MEMORANDUM

DATE:	March 8, 2021	RWDI REFERENCE #: 1904405
TO:	Anthony Witherdin	Director, Key Sites Assessments - DPIE
FROM:	Kevin Peddie	Email: kevin.peddie@rwdi.com
	Michael Pieterse	michael.pieterse@rwdi.com
RE:	ADG Natural Cross Ventilation– Sydney Metro Design Review Panel Response Waterloo Metro Quarter, Building 2 – Central OSD

NATURAL CROSS VENTILATION

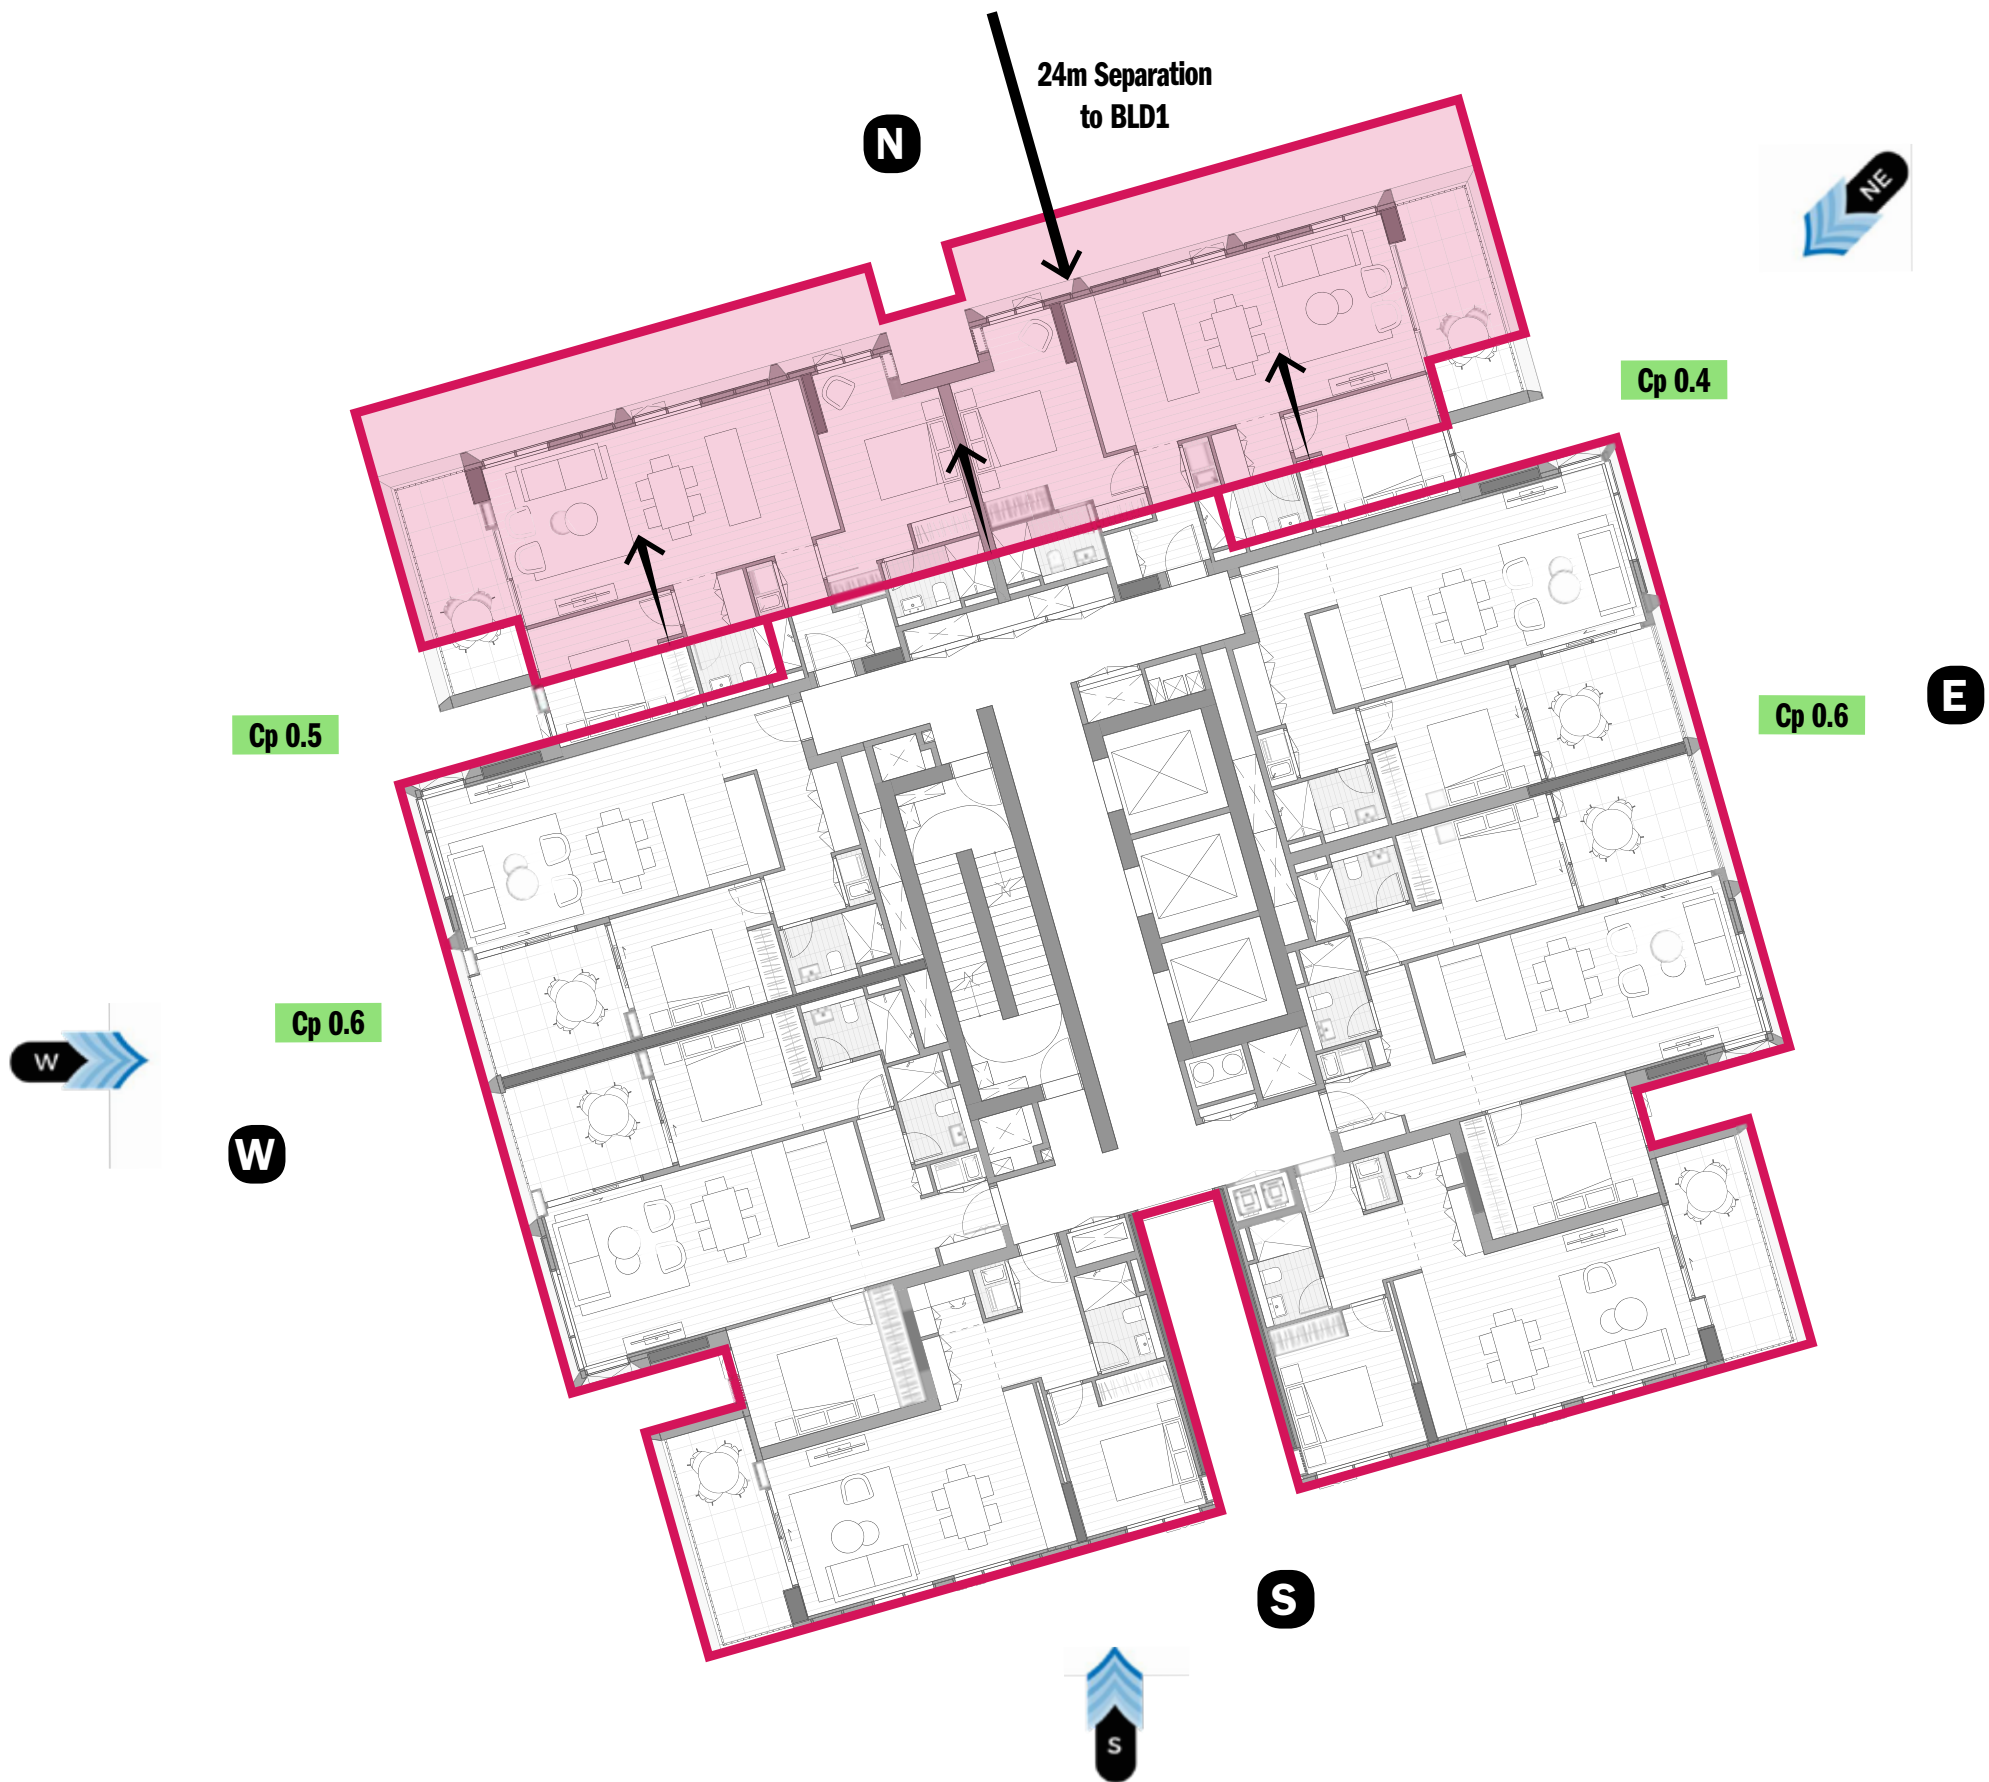
The Panel suggests that further improvement in cross ventilation could be achieved by splitting the northern 2 apartments from the adjacent east and west apartments and adding staggered openings through these walls within the resulting gap. It is recommended that the Project Team consider this option and its impact on the internal planning as part of the ongoing design development.

The Design Review Panels comments with regards to the inclusion of slots into the façade on the eastern and western aspects of the built form have been considered and discussed with the team. The inclusion of the slot into the built form has been considered and discussed with the design team in detail to understand the benefit to natural cross ventilation performance of the adjacent apartment as well as the impact to the internal planning of the building.

The inclusion of a slot into the façade will not change the current outcome from a natural cross ventilation design. This is due to the pressure within the slot being governed by the location of the external opening which will tend to stagnate deeper within the slot itself. The expected pressure differentials noted in the “ADG Natural Cross Ventilation– City of Sydney Review Response” for Building 2, prepared by RWDI, will remain unchanged, and hence there will be no difference in the number of apartments considered to have the attributes to be naturally cross ventilated.

The design consideration raised by the Design Review Panel has been considered by the Design Team, and noting the above comments have found this would not benefit the project overall when considering all planning aspects. Further to this, Building 2 is noted to currently have 75% of apartments which are considered naturally cross ventilated in accordance with the ADG, well above the 60% requirement.
